KITTITAS VALLEY FIRE & RESCUE

KVFR Prevention SEPA Comments

Project: Anderson Hay
Permit#: SE-21-00018
Date: 01/04/2021

MTA HOLDINGS TOPOGRAPHIC SURVEY
 PART OF THE SOUTHWEST QUARTER OF SECTION 22,
 TOWNSHIP 17 NORTH, RANGE 18 EAST, W.M.

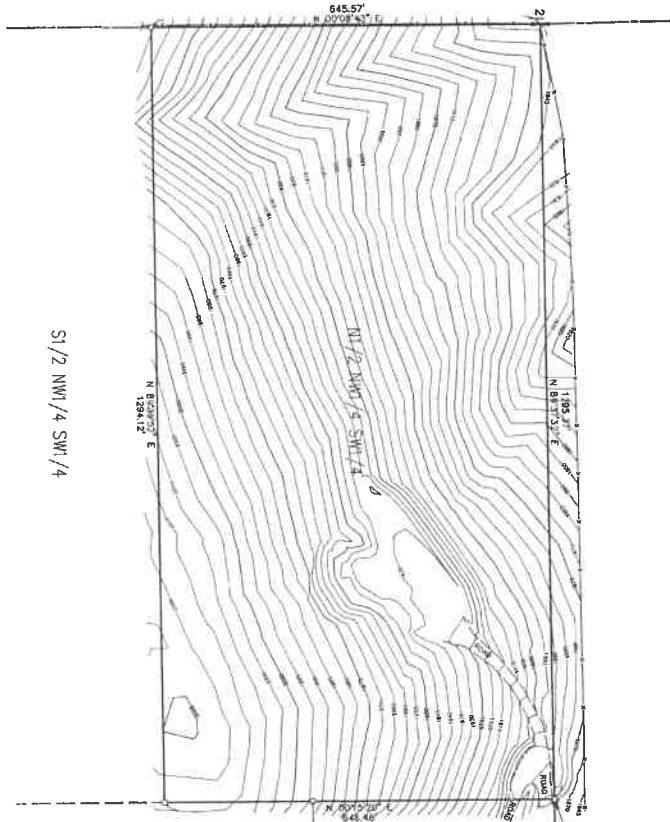
- Fire apparatus access roads exceeding 150' shall be provided with a temporary or permanent turnaround meeting the requirement 2018 IFC Appendix D.
- Fire apparatus access roads shall not exceed 10% in grade. This is especially critical in our valley's climate. Based on the provided information there are portions of the proposed road that exceed 10%.
- The IFC requires the road be capable of supporting an imposed load of at least 75,000 lbs.
- Our standard turning radius is a minimum of 23' inside and 45' outside.
